From: Dunderdale, Chris <Chris.Dunderdale@lancashire.gov.uk>
Sent: 11 February 2019 09:01
To: Robert Major
Cc: planning
Subject: RE: 3/2019/0012

Thank you for consulting the Lead Local Flood Authority (LLFA) on the above application. As I mentioned last week, the LLFA is unable to provide you with a substantive response at this time. That is because there is not enough information to complete an assessment of the development proposals. Please see details below:

Subject: 3/2019/0012

The application is a full planning application for details of the layout, scale and appearance of the buildings and landscaping of a residential development of 233 dwellings and associated works.

Drawing:
Location Plan

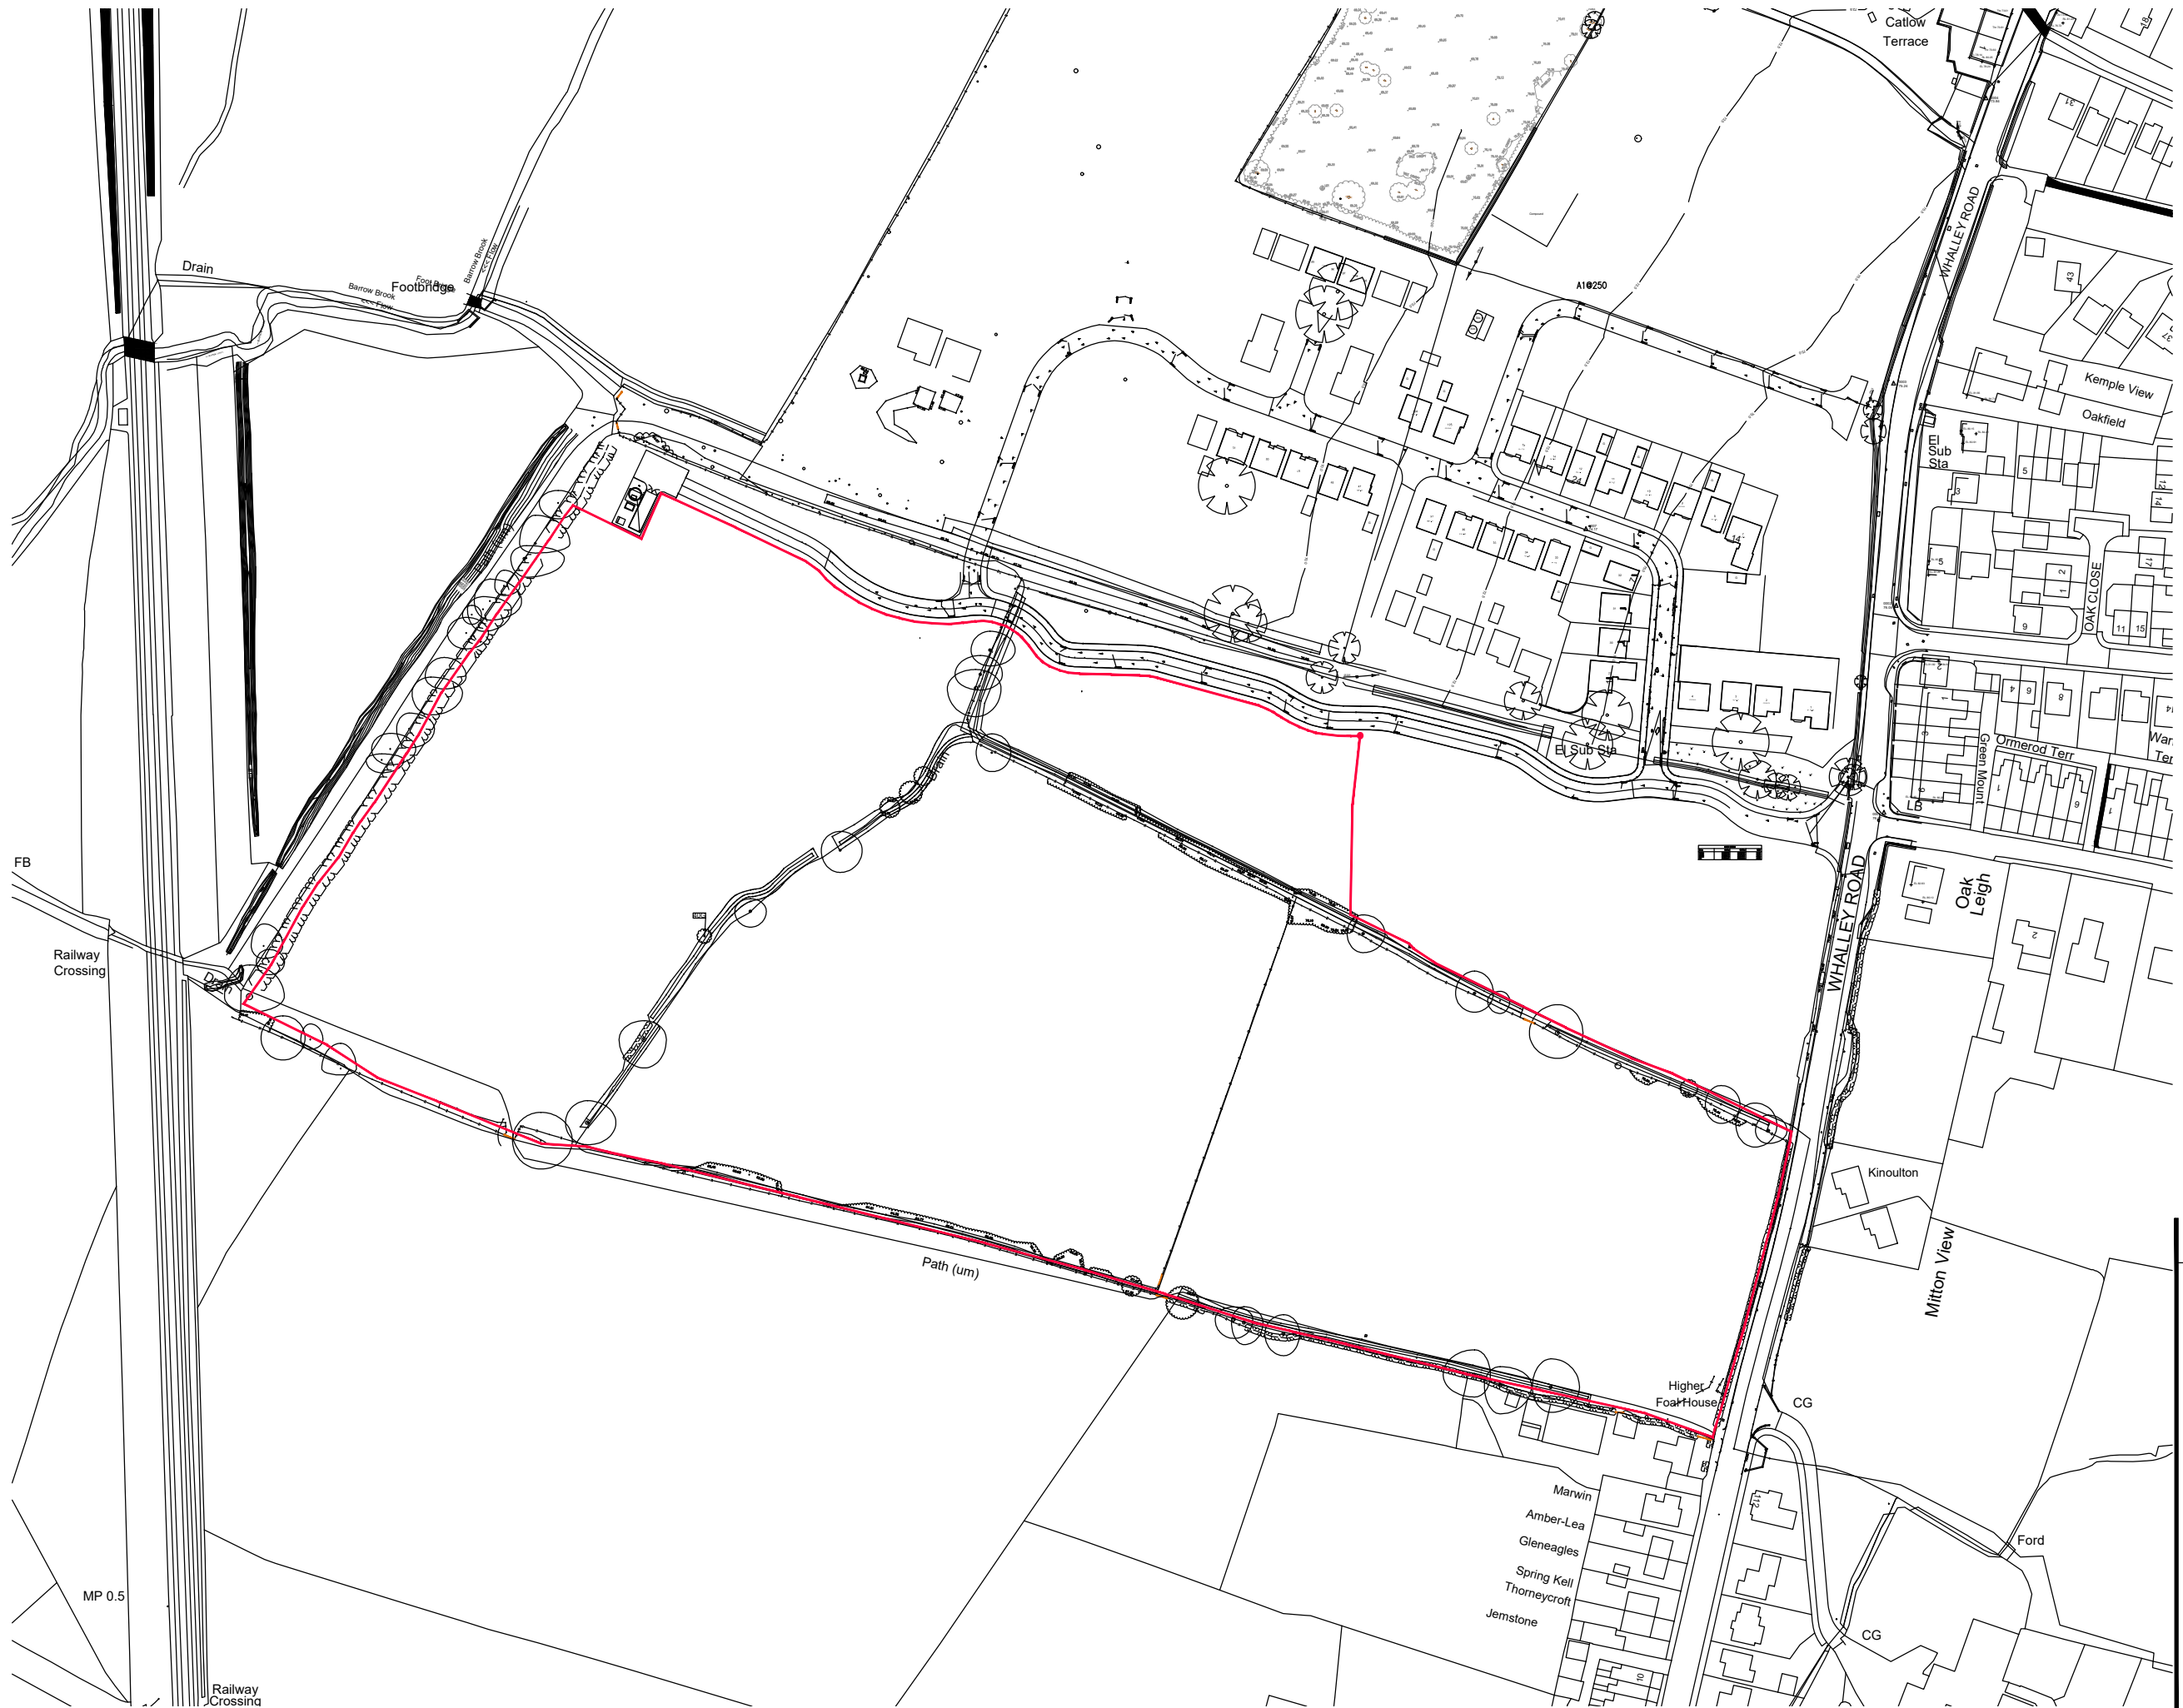
d) I note that the surface water outfall structure for drainage network 2 is to be located outside the red line boundary of the site. For completeness, I would recommend for the red line boundary of the site to be extended to include the surface water outfall structure.
